28th March 2019

**REPRESENTATIONS TO PROPOSED MANSTON AIRPORT DEVELOPMENT CONSENT
ORDER APPLICATION PINS REF: TR020002**

Iceni Projects are instructed by Cogent Land LLP (“Cogent”) in relation to the Development Consent Order (DCO) application made by RiverOak Strategic Partners Ltd (“the Applicant”) for the upgrade and reopening of Manston Airport (“the DCO Scheme”).

Figure 6
Extent of noise contours

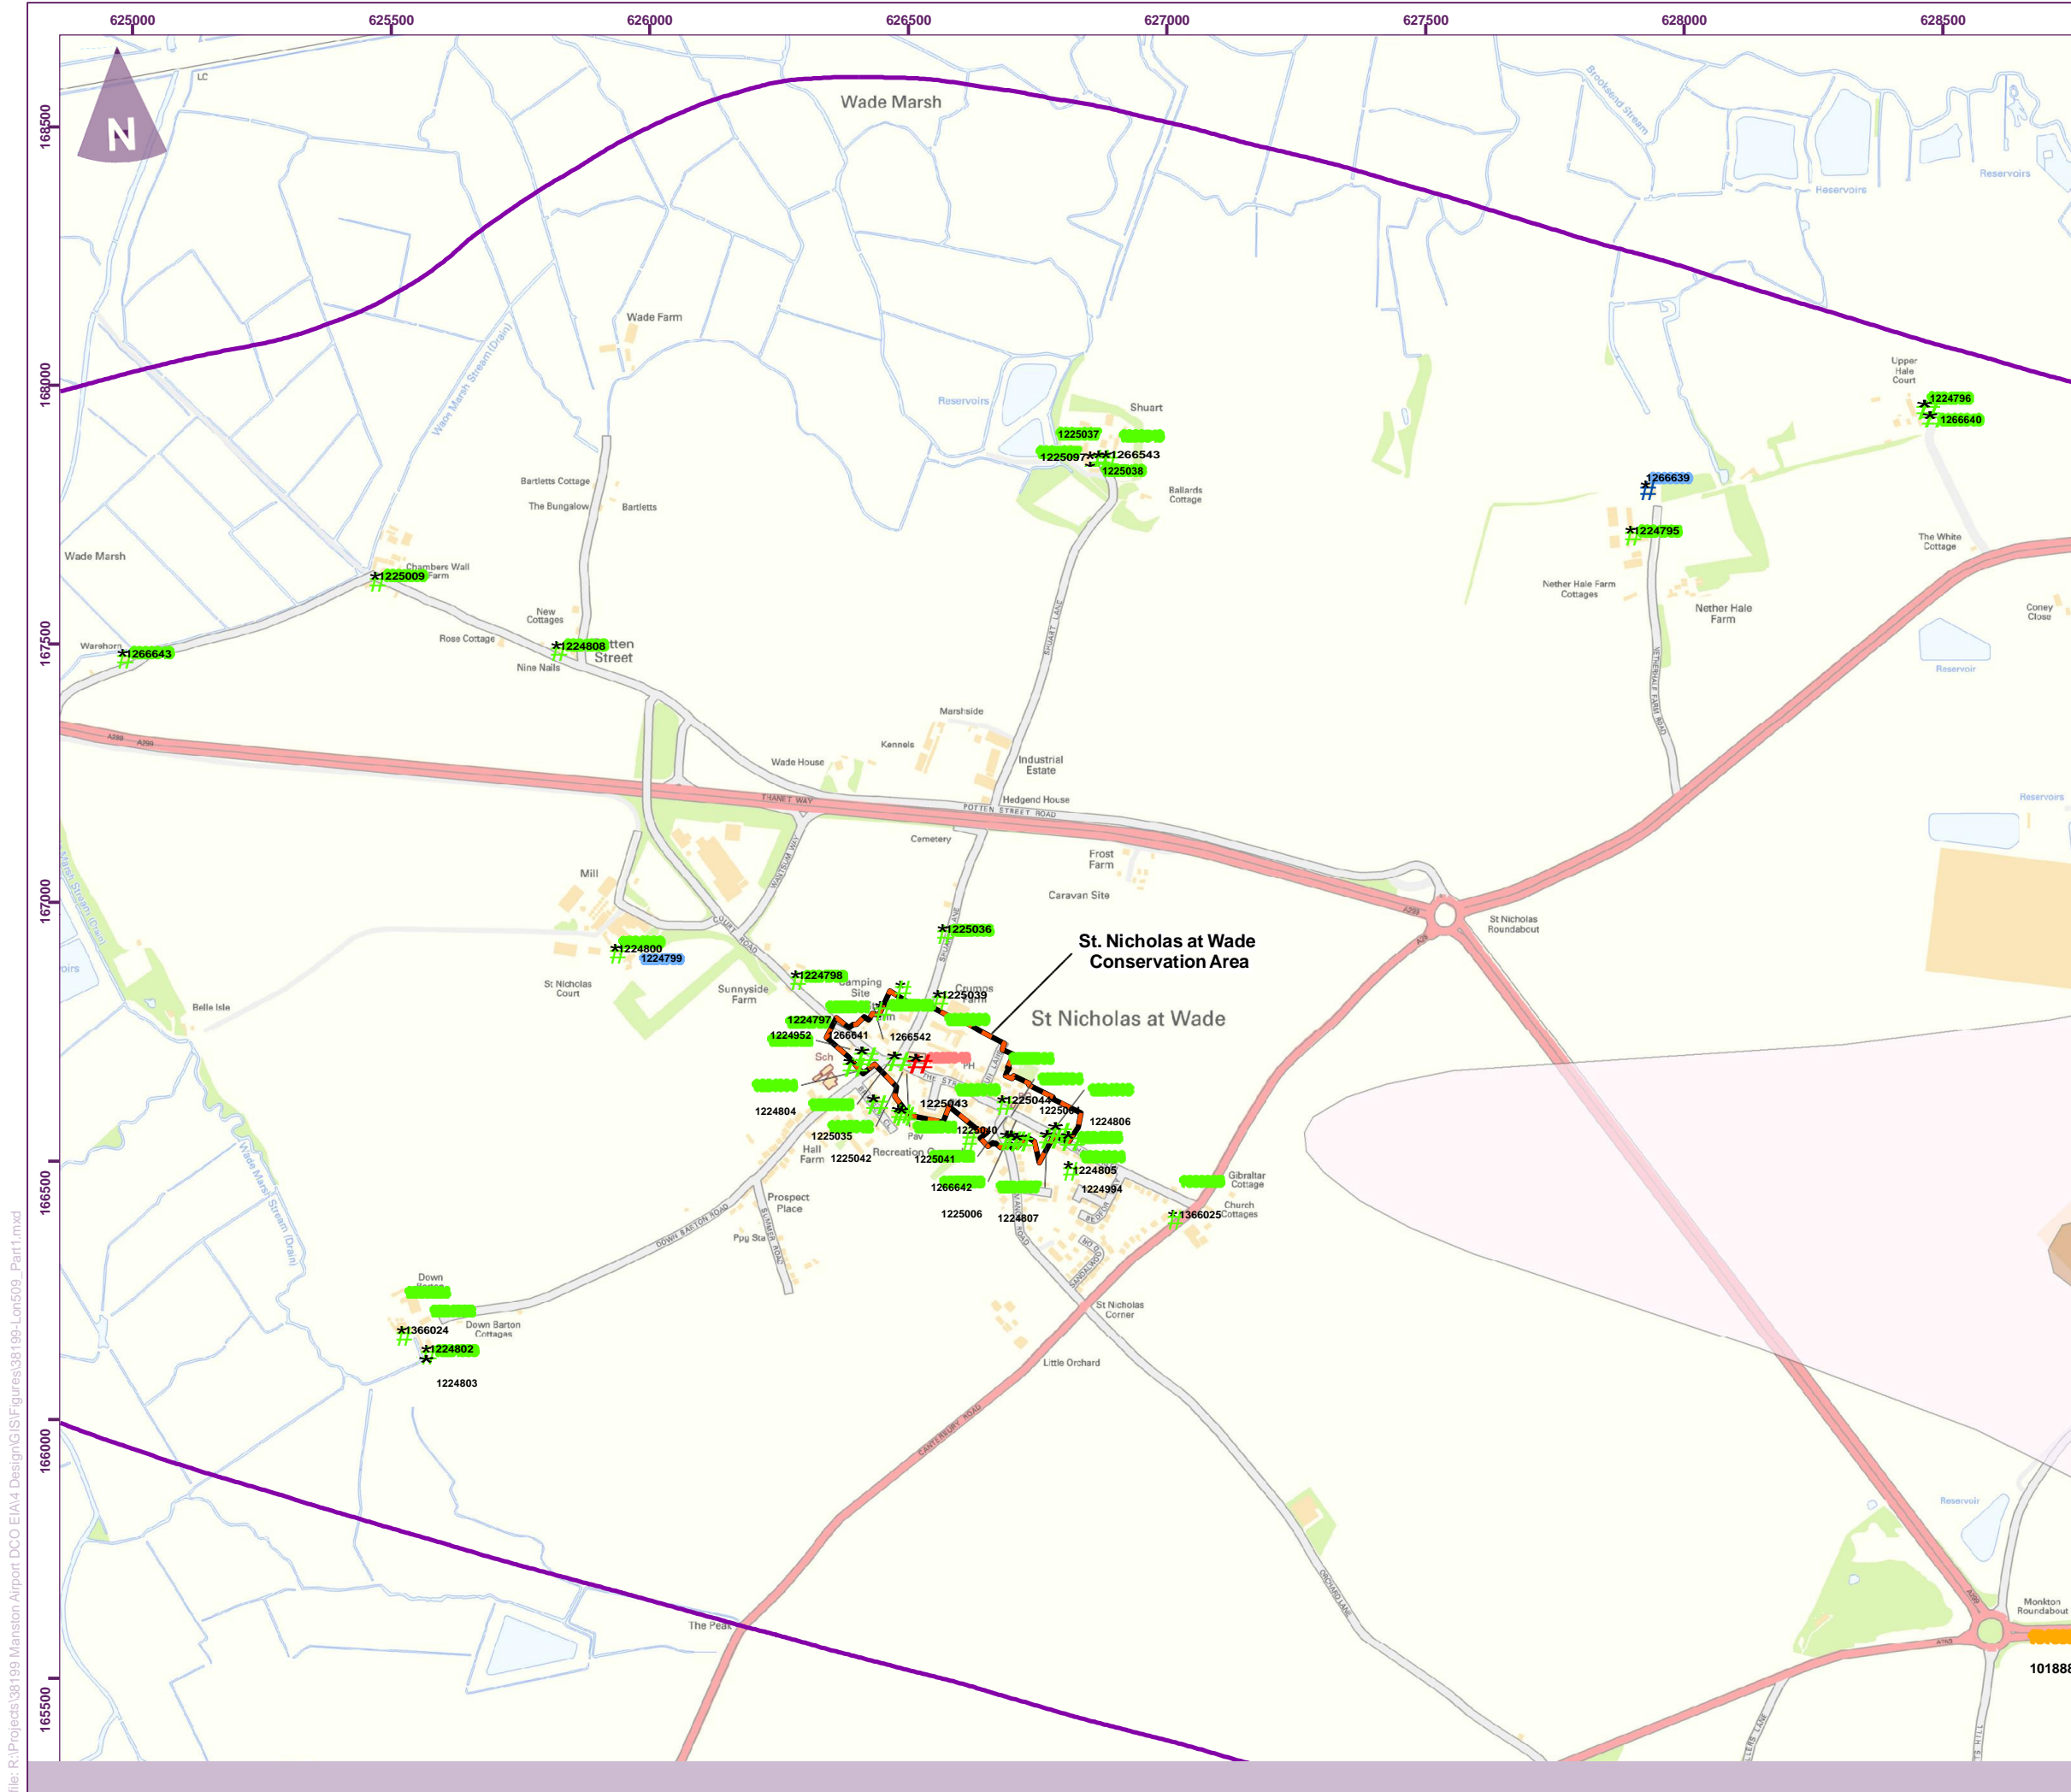
It is not possible to accurately predict the impact of more than double the increase in ATM's using the information within the DCO application. However, if we were to assume a similar mix as used in the noise models, this increase in aircraft movements, could result in overall noise levels increasing by 5 dB. This would have an effect of adding 5 dB to the noise contours (i.e. the 63 dB contour would become 68 dB; the 50 dB contour would become 55 dB and so on.

The result of the above is that the 63 dB contour could cross a large area of residential development at Manston Green resulting in a reduction in the area able to be developed for residential use.

Put simply, only half of the potential noise impact of the DCO scheme has been assessed, and the impacts on Manston Green have not be considered at all. We request that a full and proper assessment is carried that show the full noise impacts from the full capacity of the DCO scheme and that mitigation is proposed that will reduce the impacts on Manston Green.
